Reference: DOC21/820193
Date: 1 October 2021

New High School in Bungendore – SSD-14394209 – Department of Education

The EPA has reviewed the Environmental Impact Statement (EIS) and the supporting documents and provides detailed comments in Appendix A.

Fig. 11 Site Erosion & Sediment Control Plan – REFER APPENDIX B FOR FULL DRAWING(S)

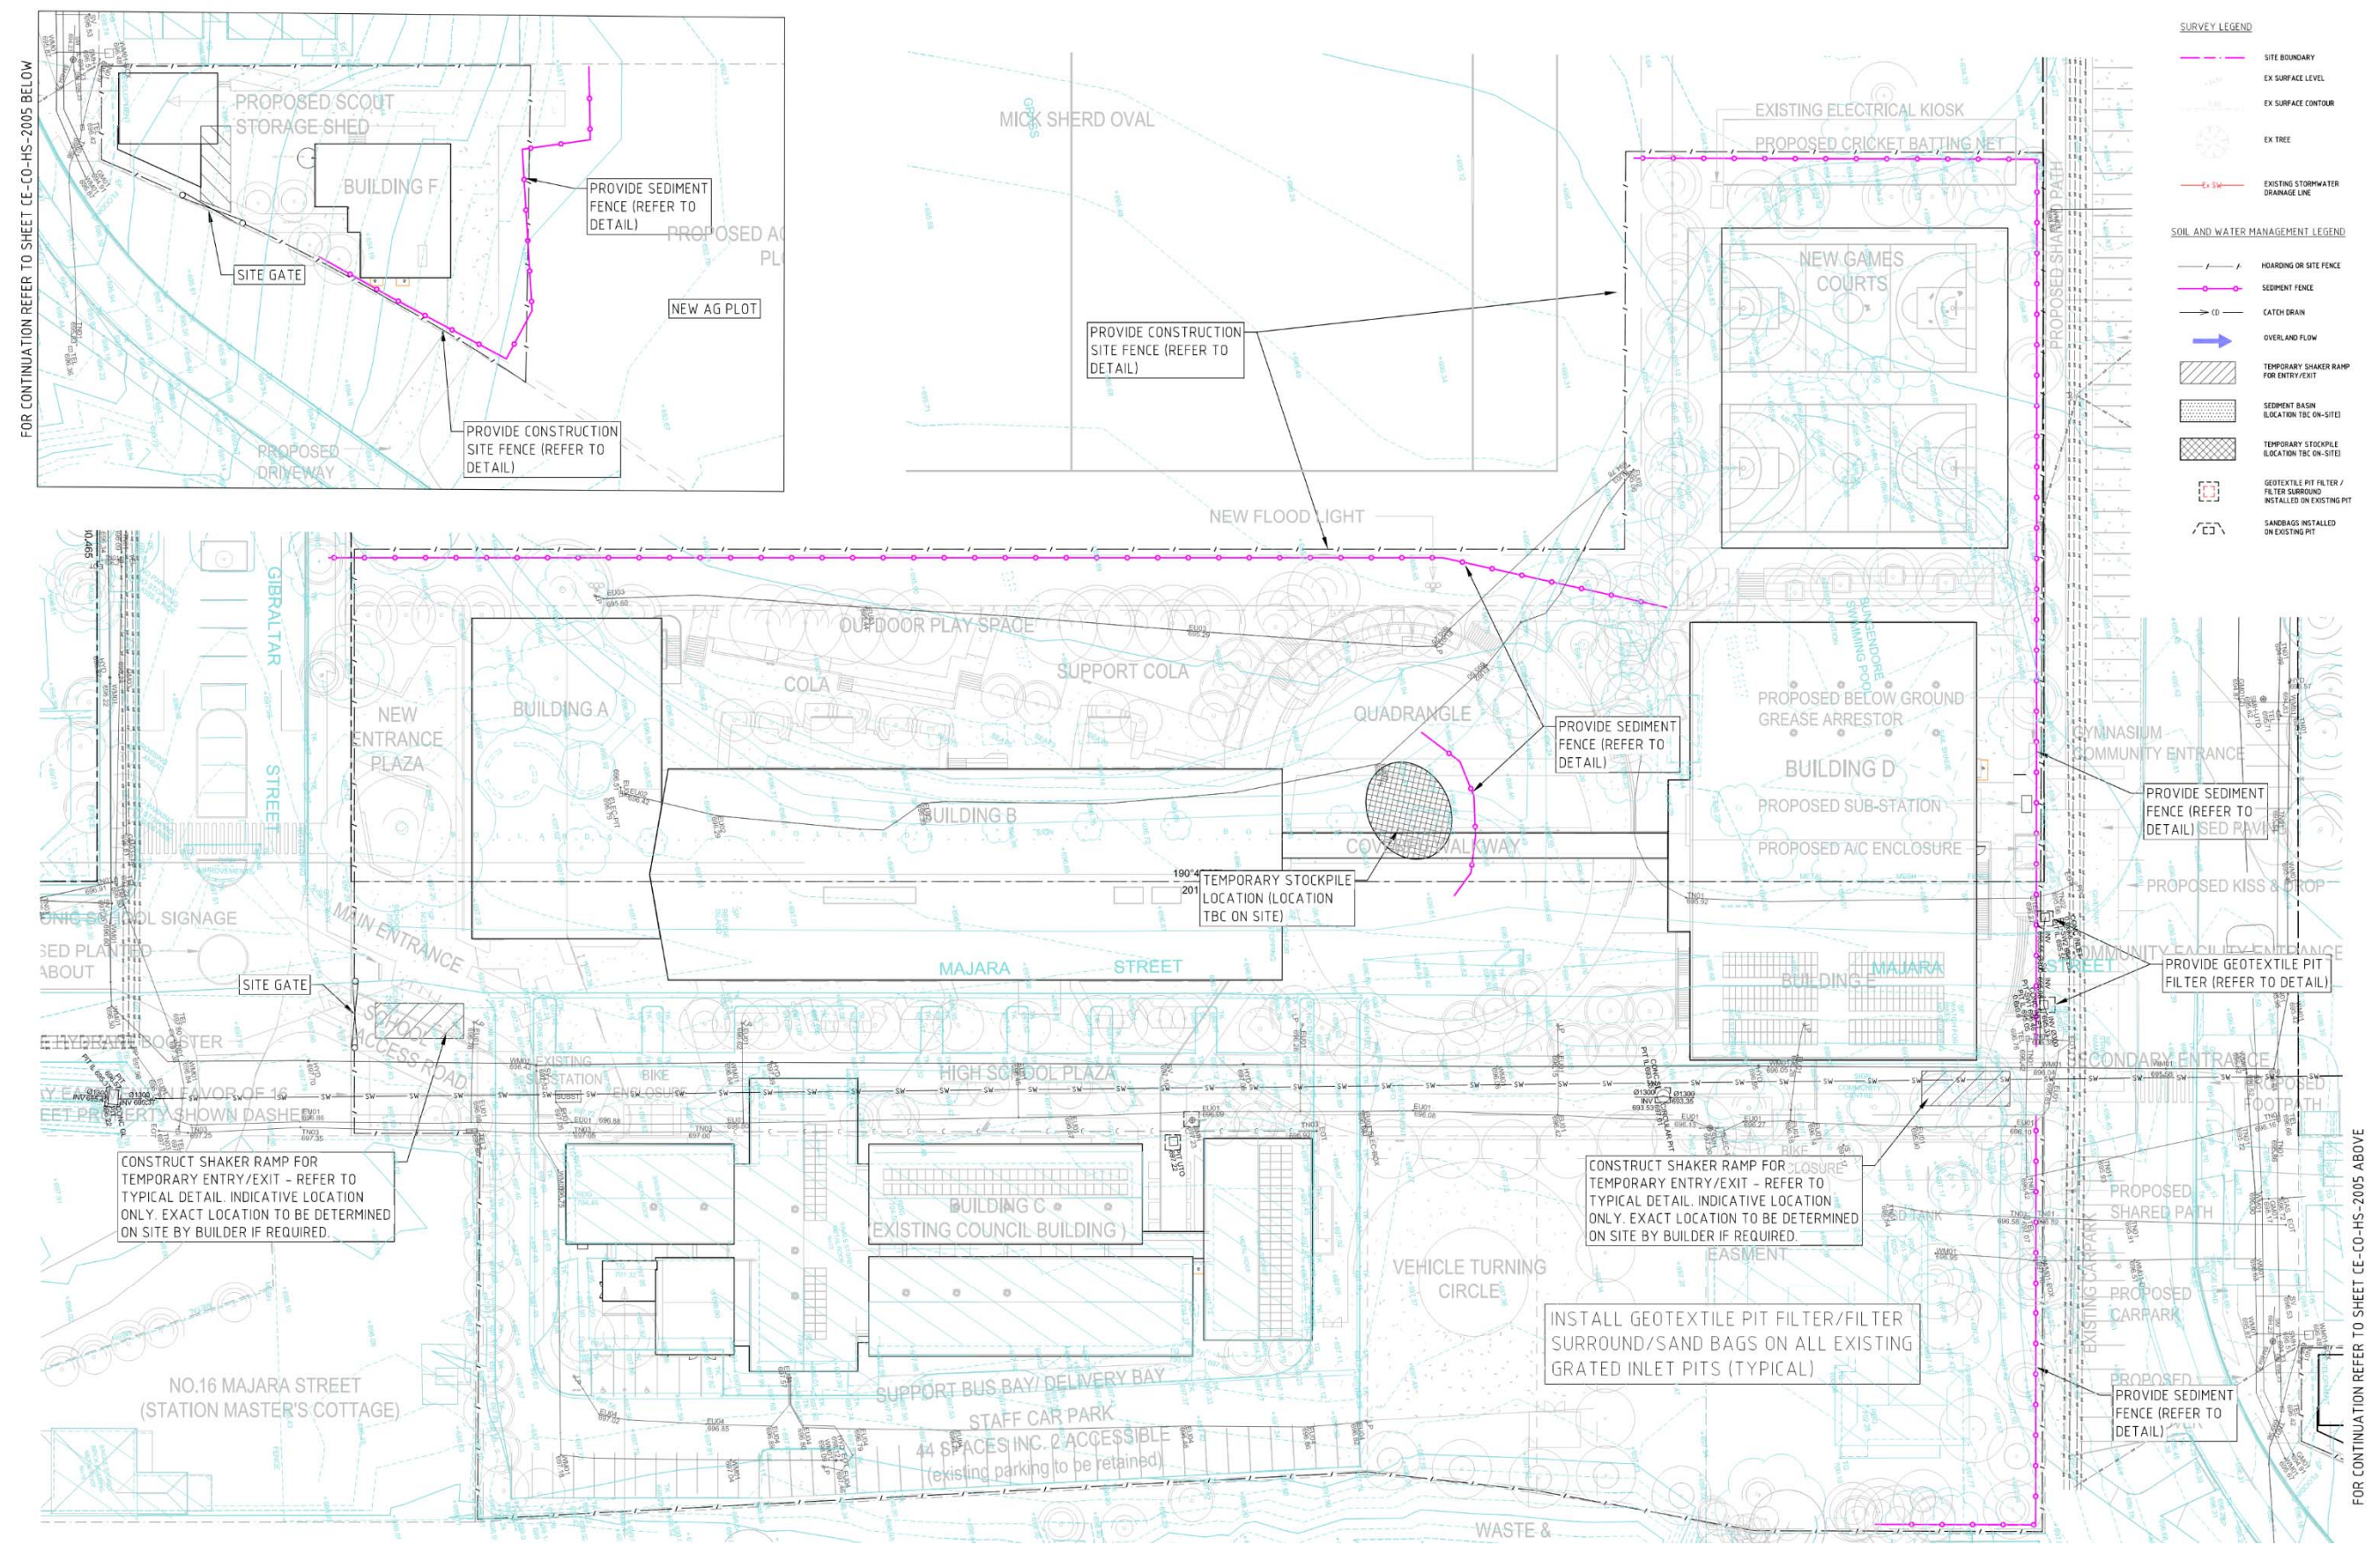
The receiving environment for the proposal is Turallo Creek which form part of the Lake George catchment. As such the EPA considers that a high standard of planning, implementation and operation of sediment and erosion controls will be required to protect the NSW Water Quality Objectives and environmental values of the catchment.

The EPA notes that the EIS and supporting documents outline that additional sediment and erosion controls are to be implemented during wet weather events. The EPA recommends that these additional controls are developed and implemented at a high standard to protect the receiving environment. Typical measures that can be implemented include covering high risk areas with geotechnical material and maintaining site traps and check dams. The EPA further recommends these additional measures are captured as formal procedures and all relevant team members are aware of the procedures.
